Application for removal or variation of a condition following grant of
planning permission. Town and Country Planning Act 1990.
Planning (Listed Buildings and Conservation Areas) Act 1990

Variation of condition 2 imposed under EP/145/17/HH to
change drawing number of plan drawing to reflect
rebuilding of section of wall rather than retention.

Town/City: East Preston

DRAWING TITLE  
**Proposed Ground Floor  
and Site Plans**

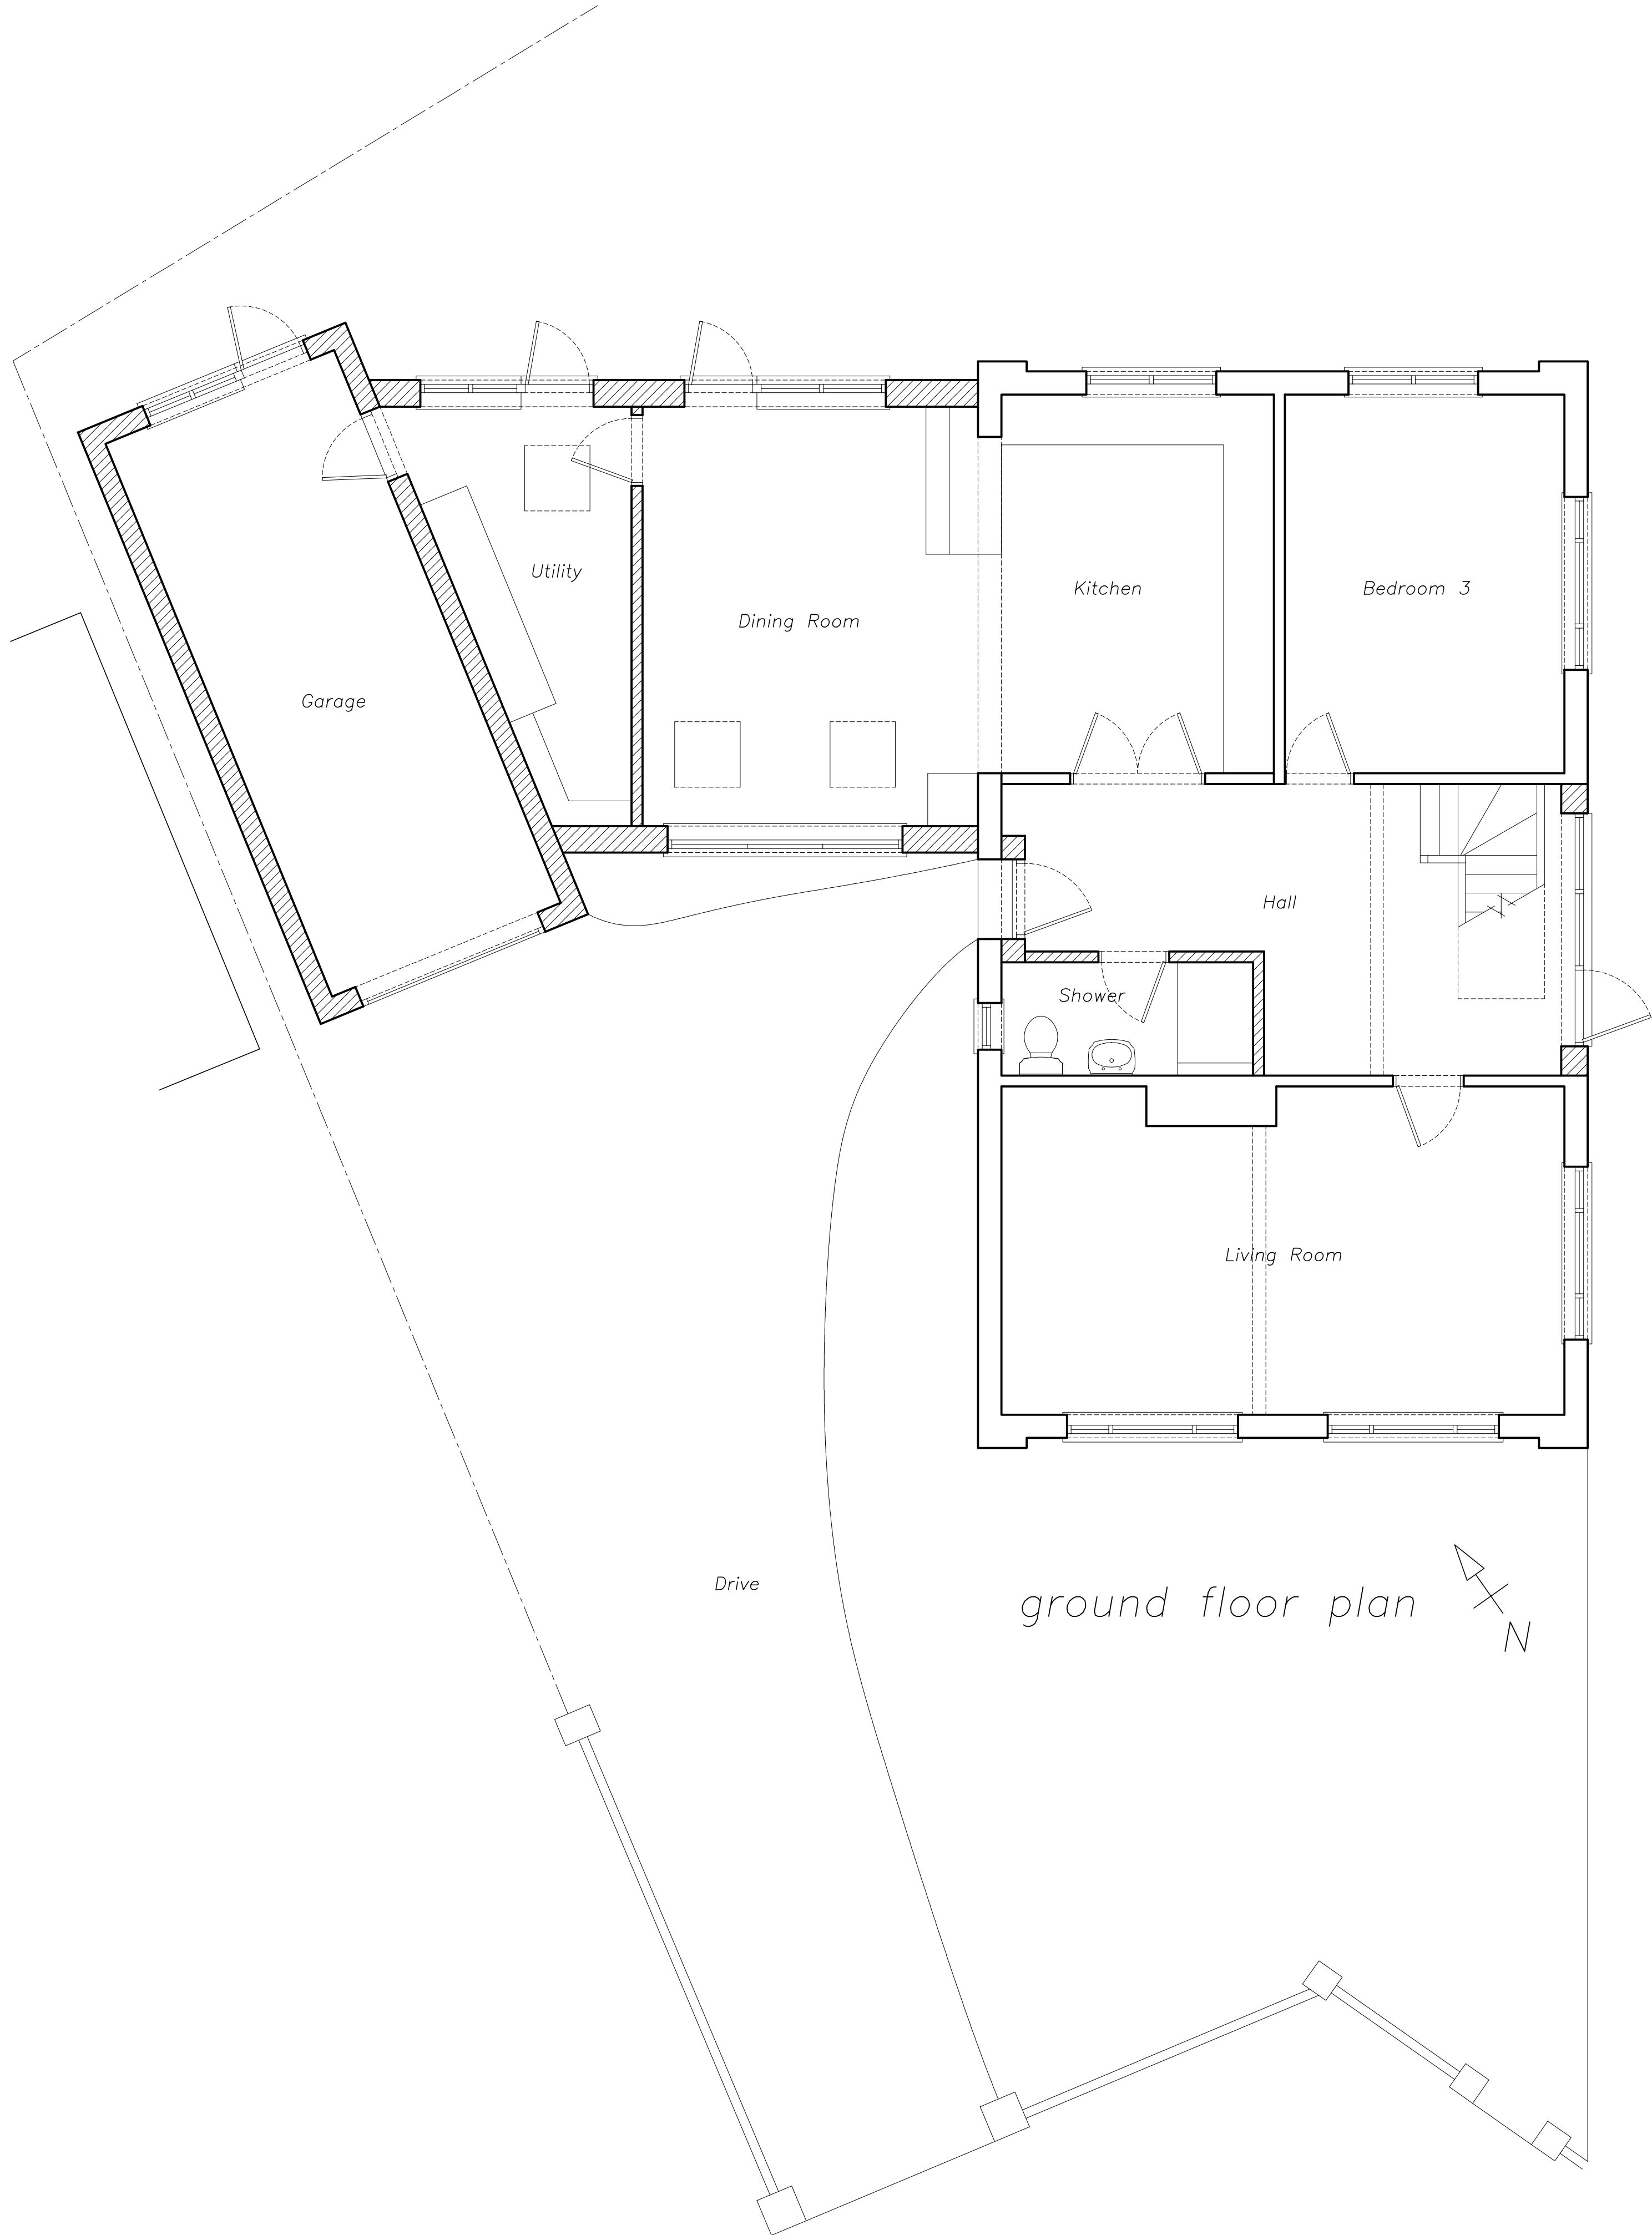
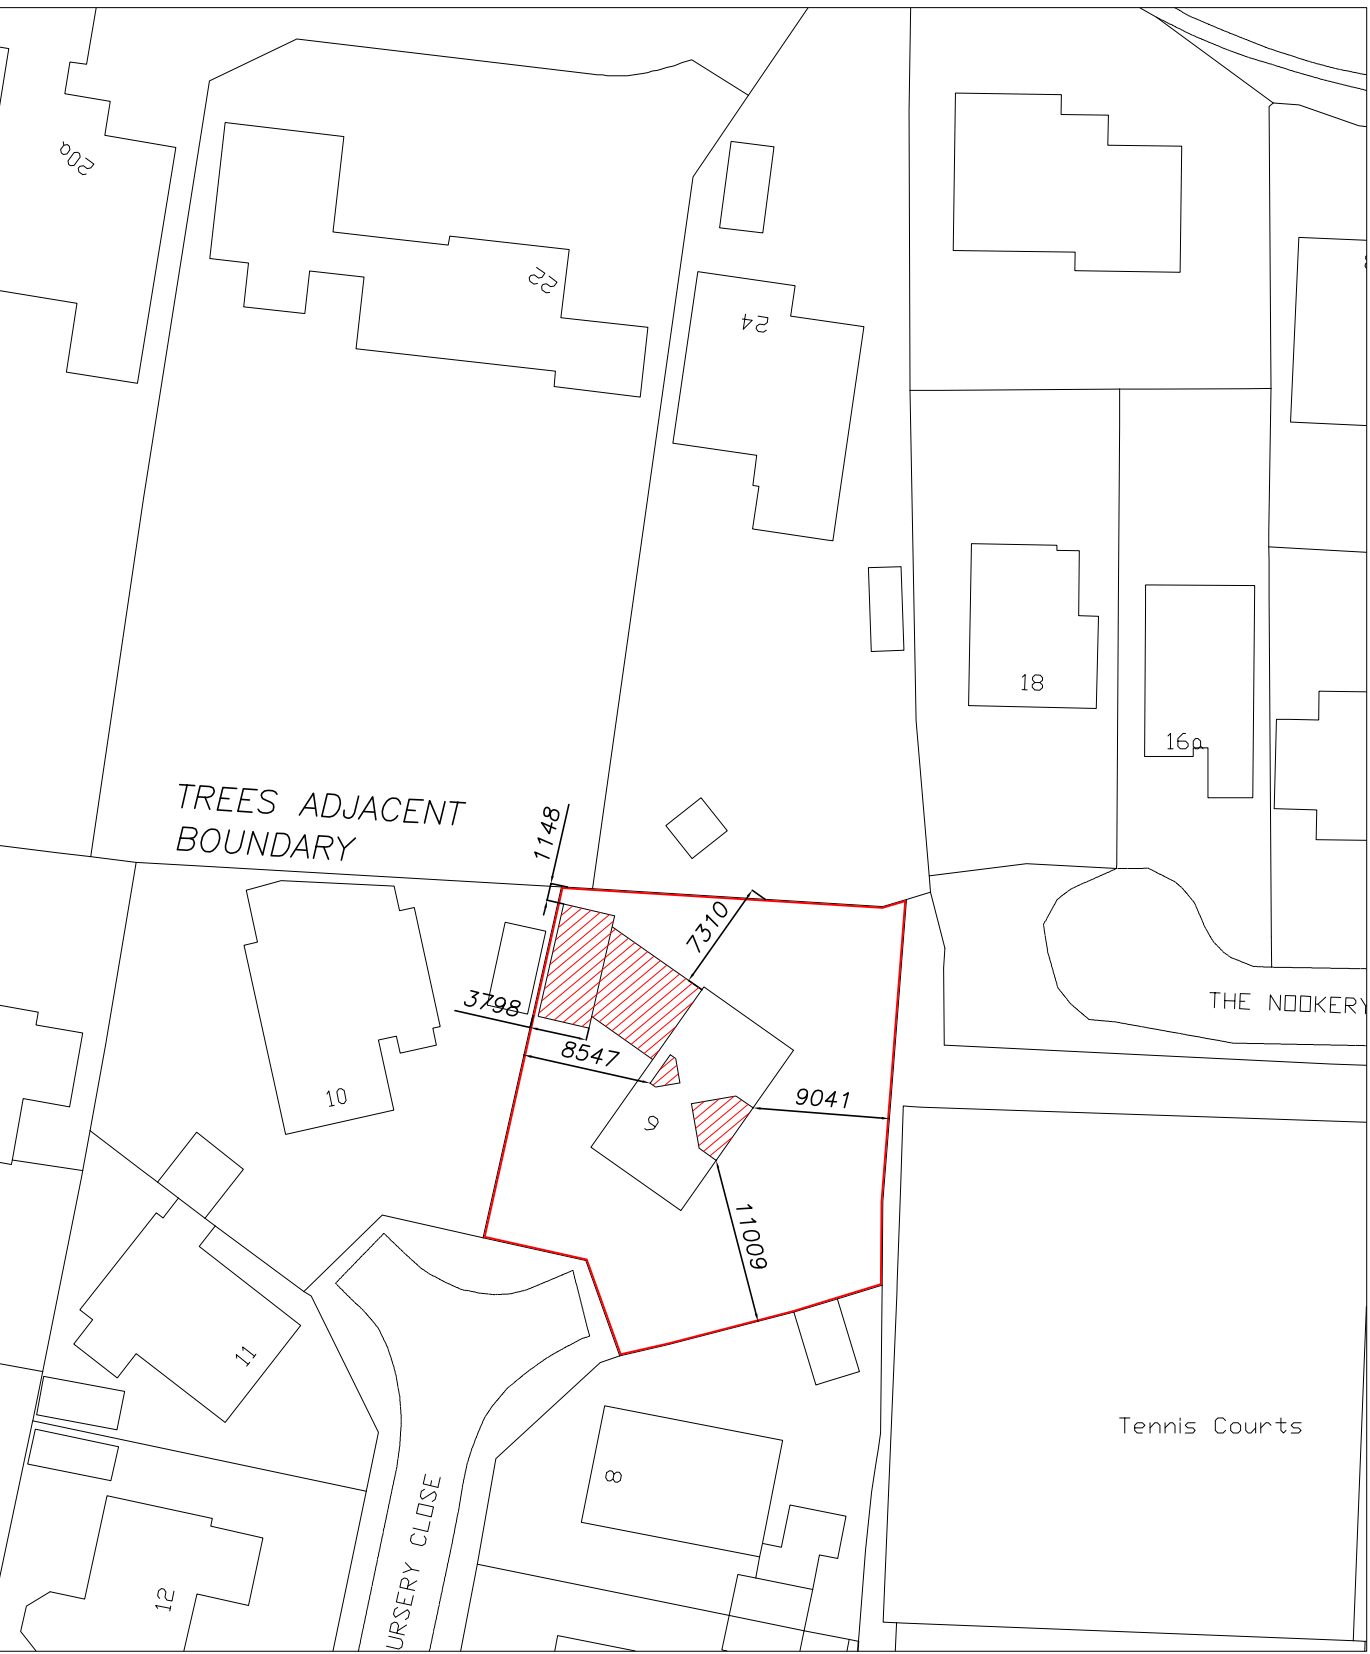
Condition 2. Change drawing number of plan drawing to reflect rebuilding of section of wall rather than retention.

1. Retaining the original western flank and slab would have been inconsistent with developing the garage in accordance with current building regulations

2. To ensure the structural integrity of the developed garage.

3. The original approval already implicitly allowed the demolition and reinstatement of the eastern flank the rear of the garage and therefore the proposal is neither a fundamental nor substantial difference to the original, approved application. In fact, the western wall will be sited in the original position.

Remove reference to approved plan 17-085-7c and add reference to plan 17-085-7d.
